Chapter 16.09

CLUSTER PLATTING, CONSERVATION and AGRICULTURAL PLATTING

SWAUK RANCH CONSERVATION PLAT

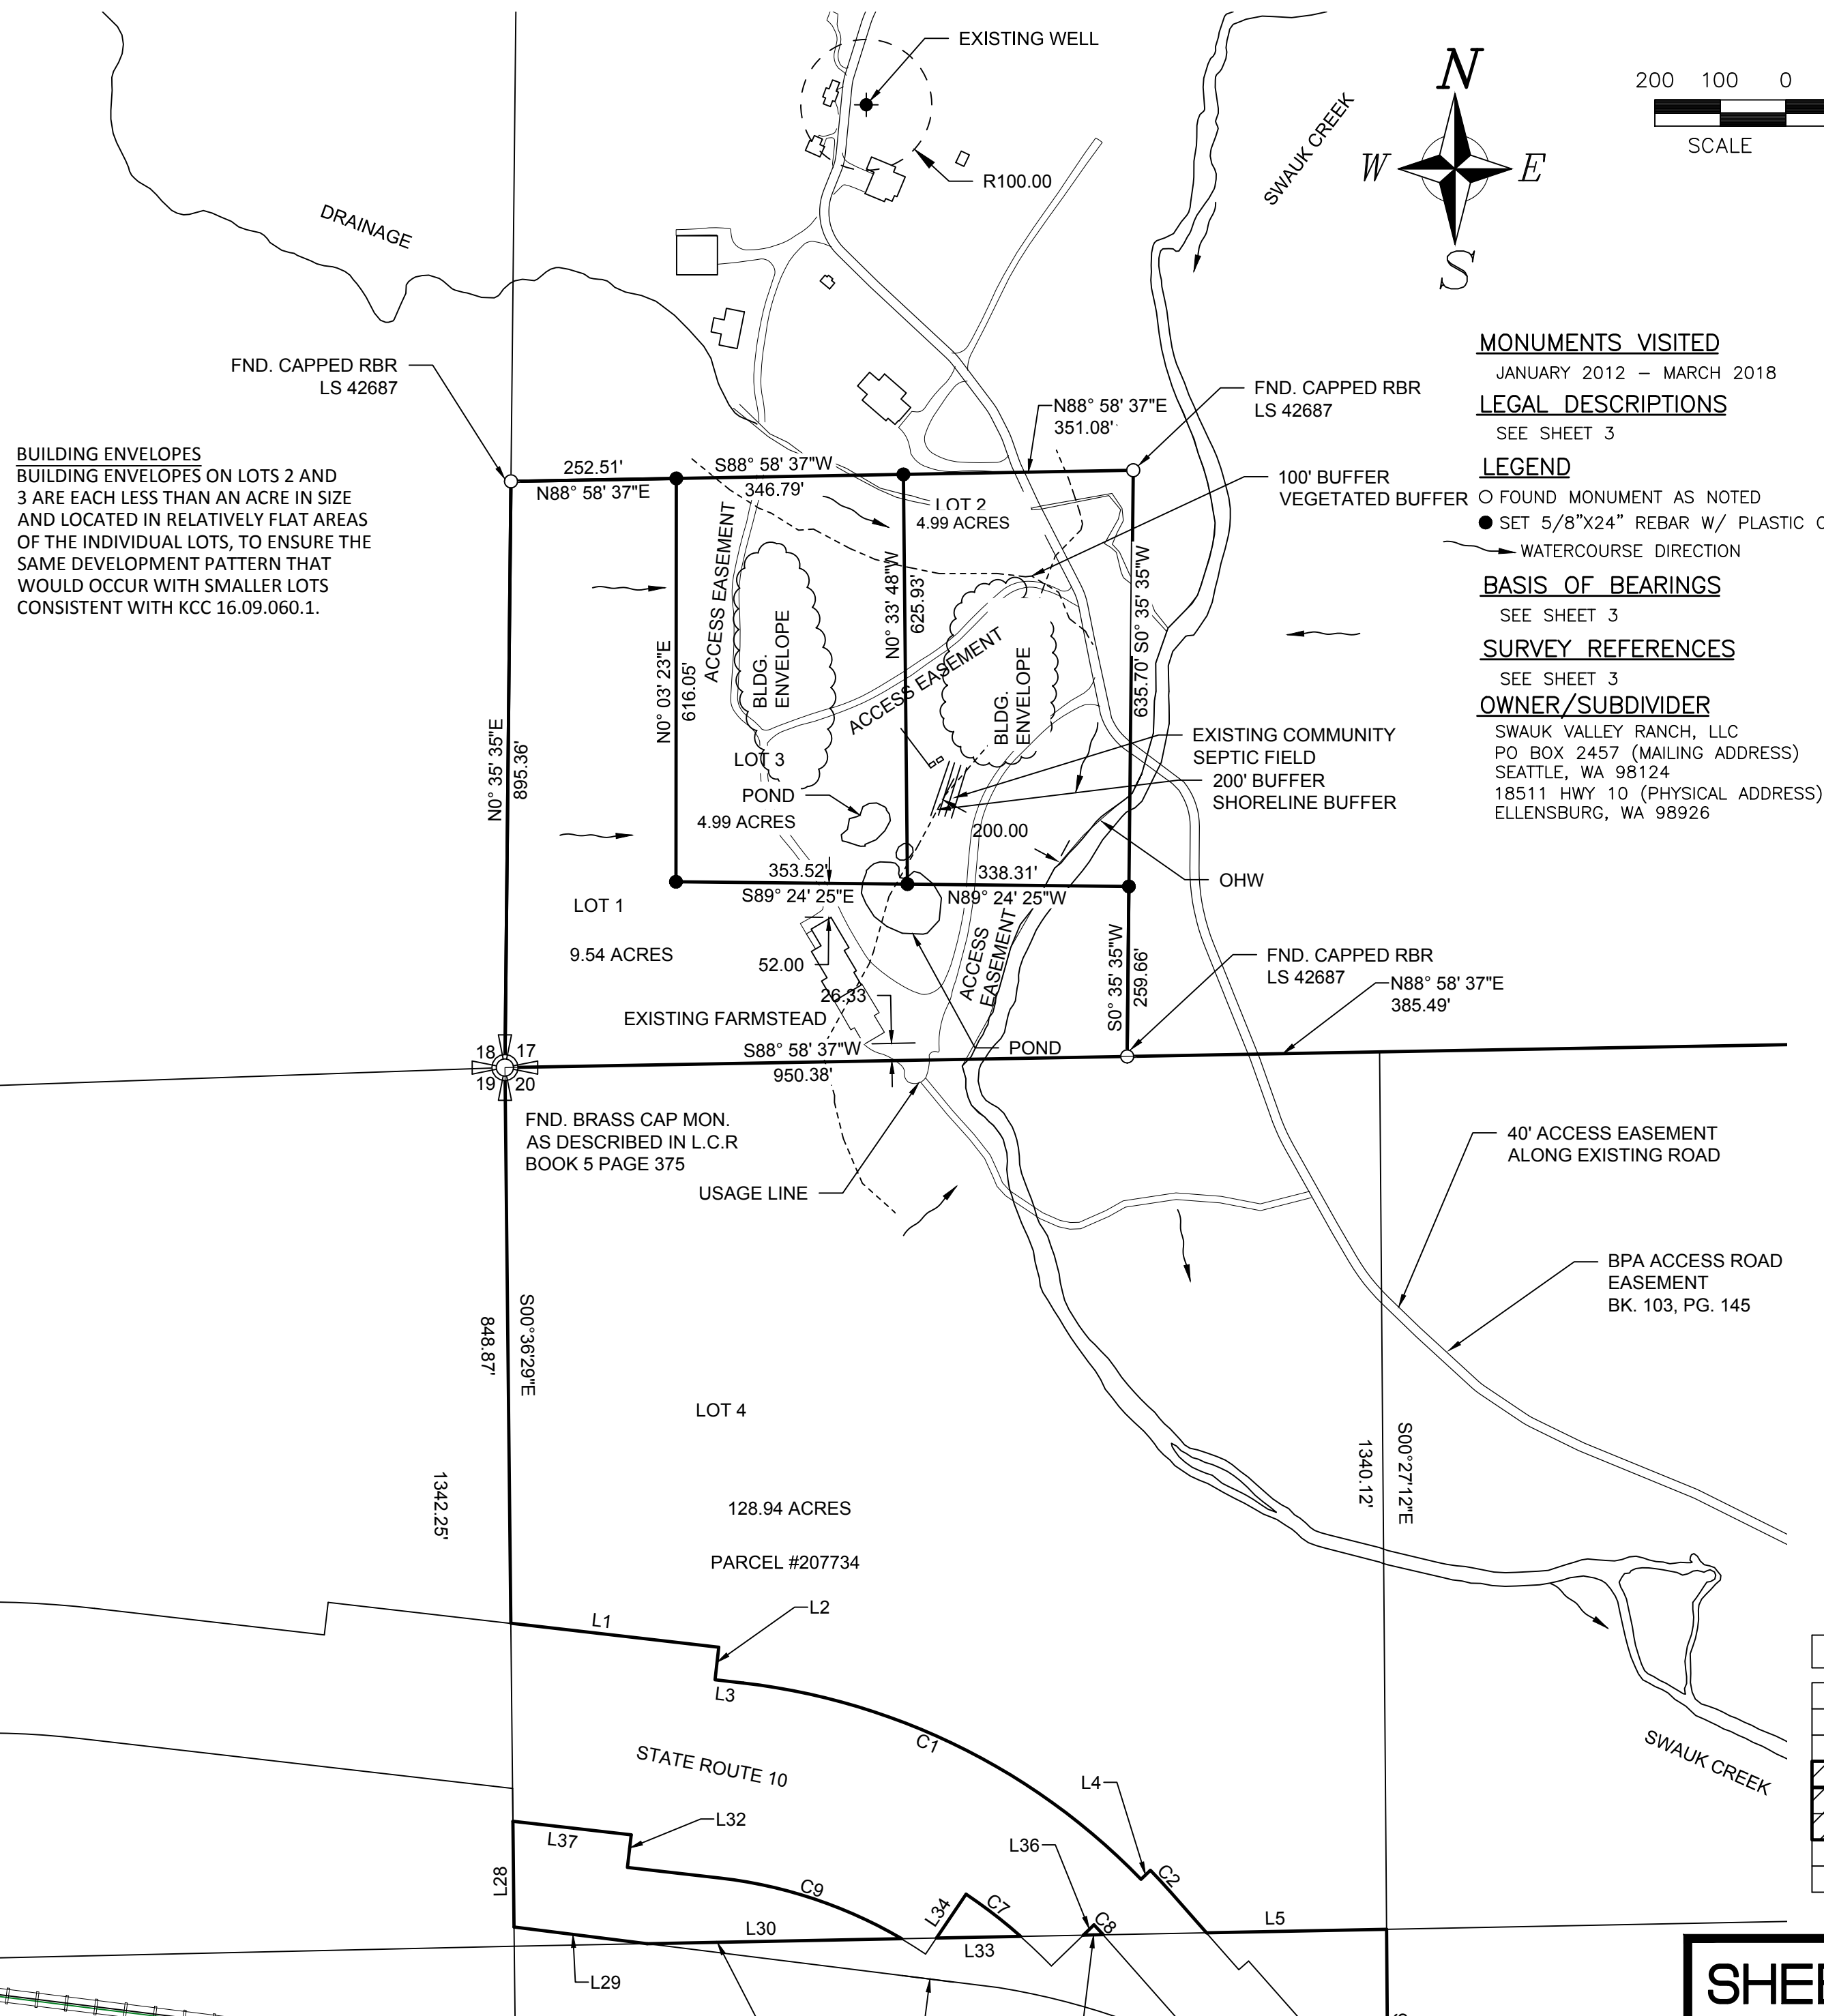
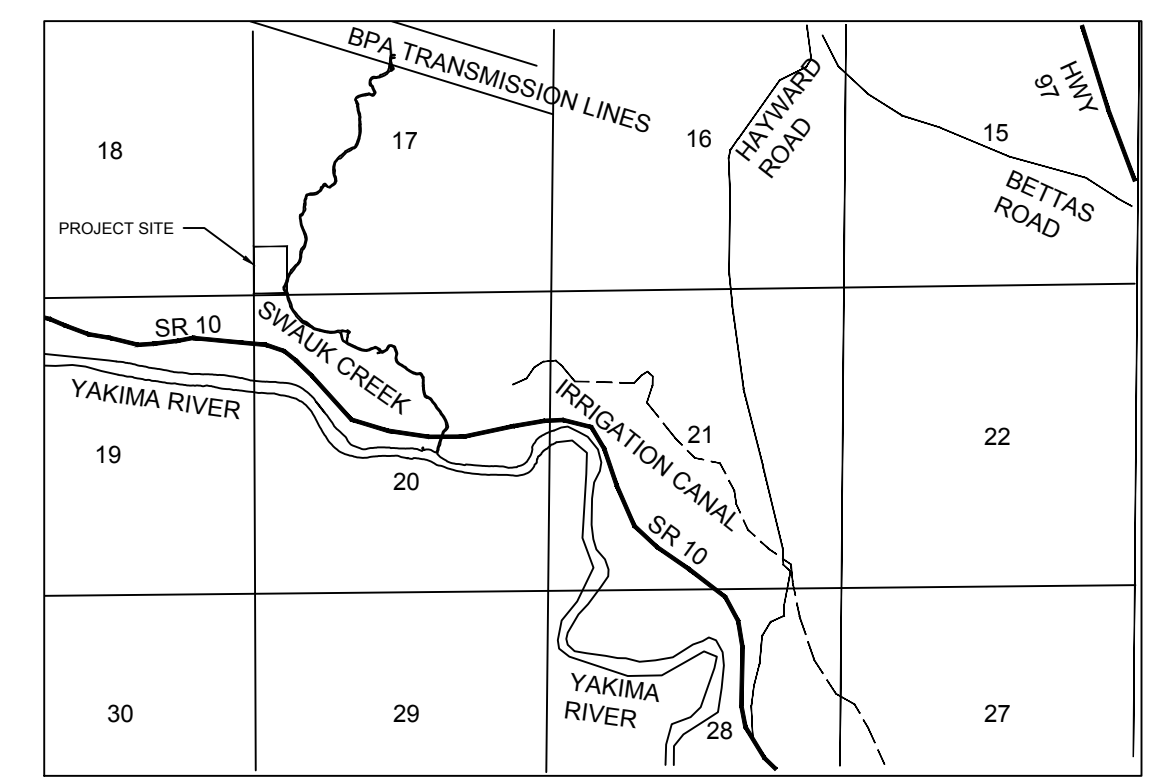
7. Road Names. The location, width, centerline, and name or names or number of all streets within and adjoining the subdivision;
8. Easements. The location and width, shown with broken lines, and description of all easements. Easements may be described in the plat restrictions in lieu of being shown on the plat drawings; (Might be an issue, I will see if Justin has a problem: Easements shown with solid lines)

11. Surrounding Area. All surrounding property shall be shown in dotted lines and letters with names of plats, roads, adjoining lots, canals, and etc., and if un-platted shall be so indicated; (Might be a code cleanup issue: I only see this in older plats).
